RE: Notice of Decision – Johnson Variance (V-08-00011)

RE: Comments to Johnson Variance (VA-08-11)

This letter shall serve as formal comments to the Johnson Variance (VA-08-11) from the Kittitas County Community Development Service/ Building Division. These comments are only in regards to the actual structure.

WOOD LOT
LINDWOOD # 31
SHADOW LANE
26x40 GARAGE
IX PARCEL #1
20-14-0253

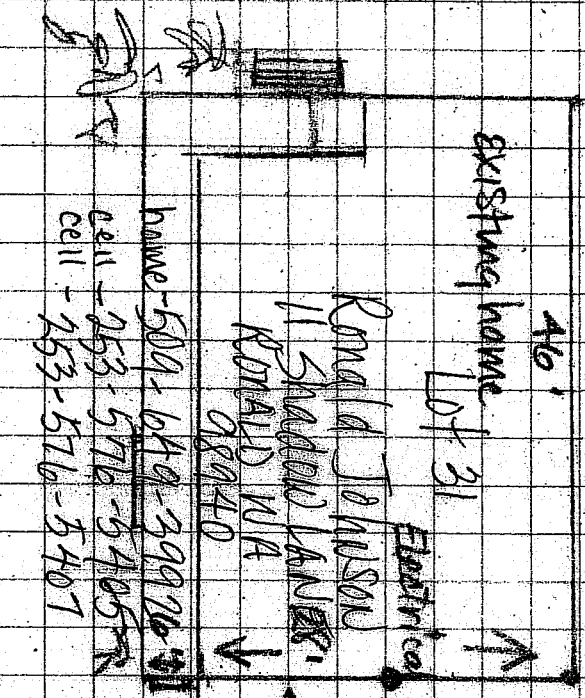
- A. Unusual circumstances apply to this property and do not apply generally to other properties in the area.
The garage shall be constructed 6 feet from the existing single family residence and 10 feet from the property line which reduces the variance approval to 5 feet. Due to the size of the lot and placement of the existing single family residence, this is the best place for the detached garage to be constructed.

- C. The authorization of such variance will not be materially detrimental to the public welfare or injurious to property in the area.
Due to the proximity of the building to the property line, the structure shall be constructed in such a manner as to prevent snow from sliding off the roof and impacting the adjacent property. The structure shall be designed with "snow-guards" that will hold all of the snow on the roof.

- **The structure should be constructed in such a manner as to prevent snow from sliding off the roof and impacting the adjacent property.**
- **It is recommended that the structure be designed with "snow-guards" that will hold all of the snow on the roof.**
